**Addendum No. 1**

RE: Contract ID C202757

WBS # 2CR.10741.9

NC-102 from Bridge #53 to the intersection with NC-43

PROJECT REFERENCE NO.	SHEET NO.
2CR.10741.9	2
ROADWAY DESIGN ENGINEER	PAVEMENT DESIGN ENGINEER

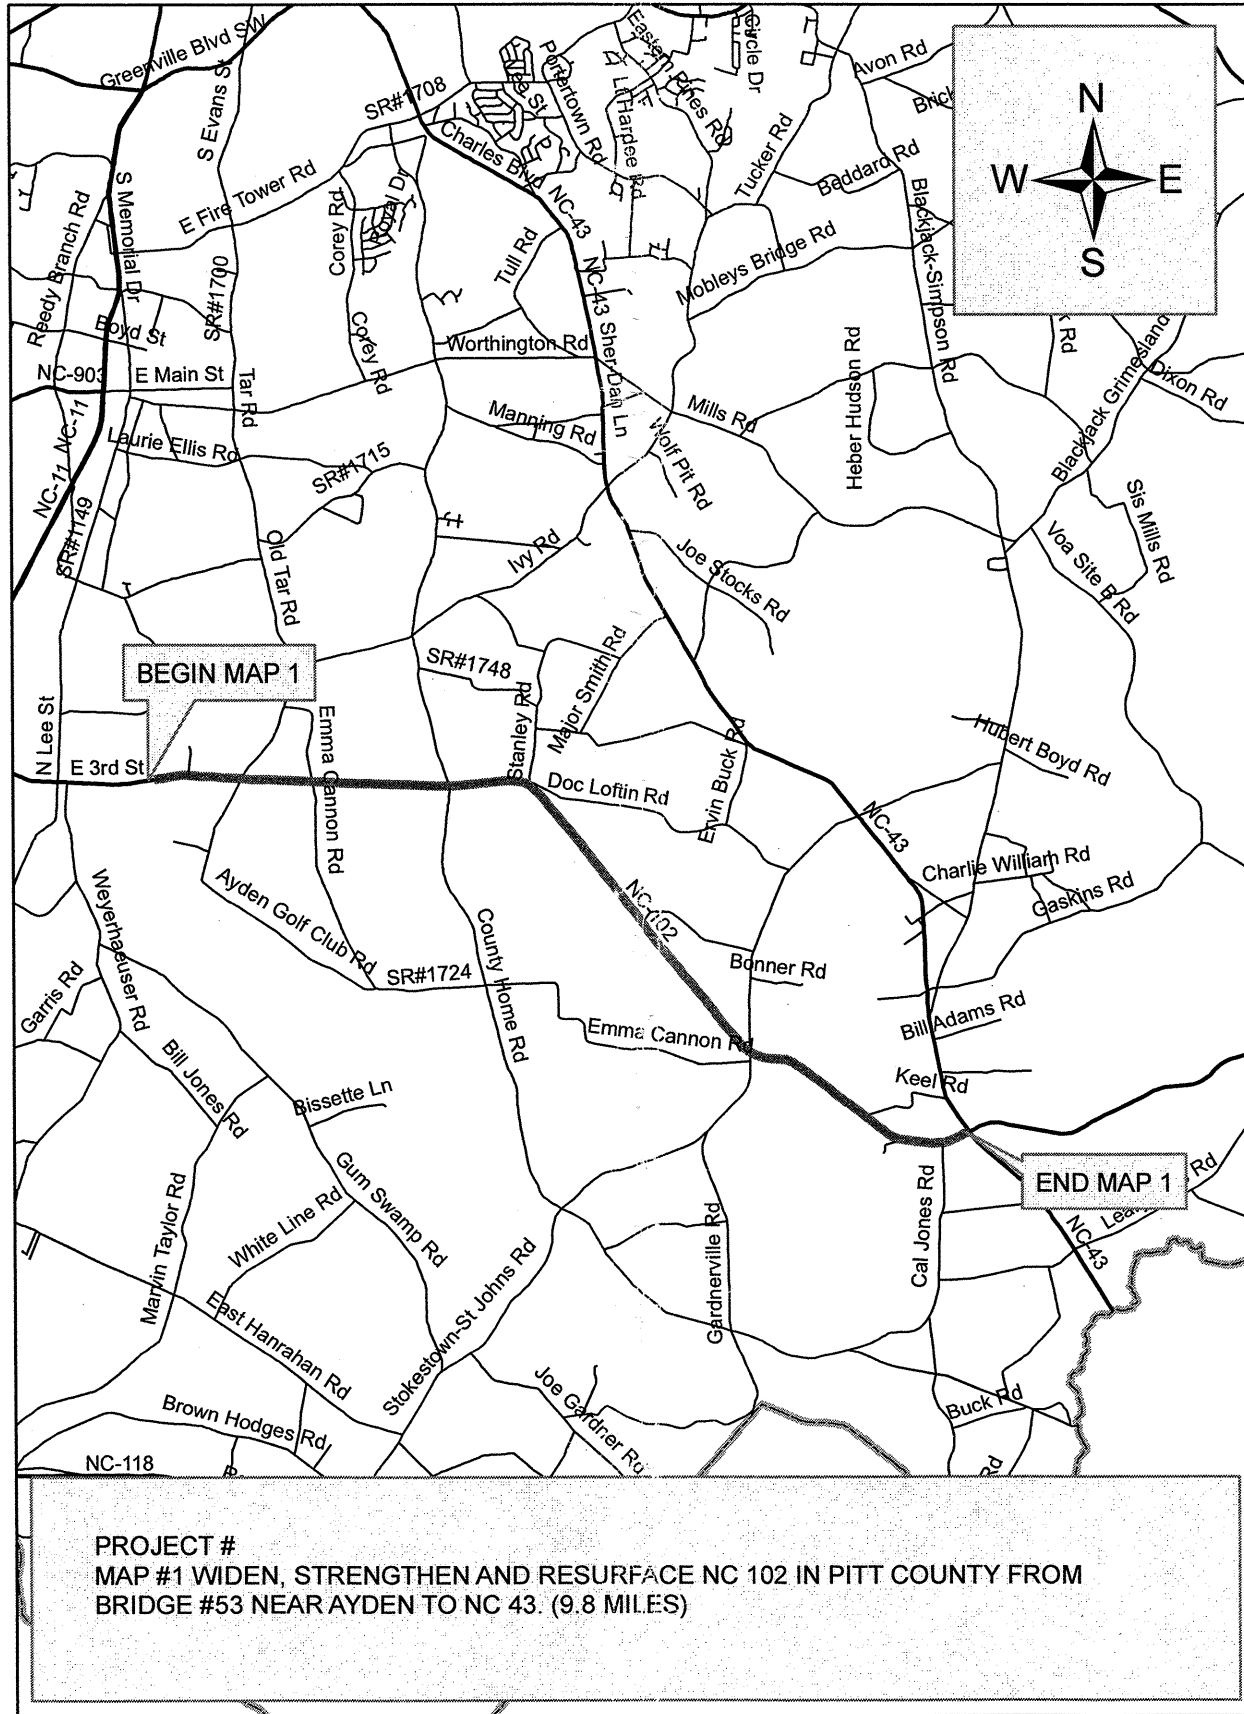
On Sheet No. 2 the Pavement Schedule has been revised to add the words "TO BE PLACED IN ONE LIFT" in the description for E1 Please void Sheet No. 2 in your plans and staple the revised Sheet No. 2 thereto.
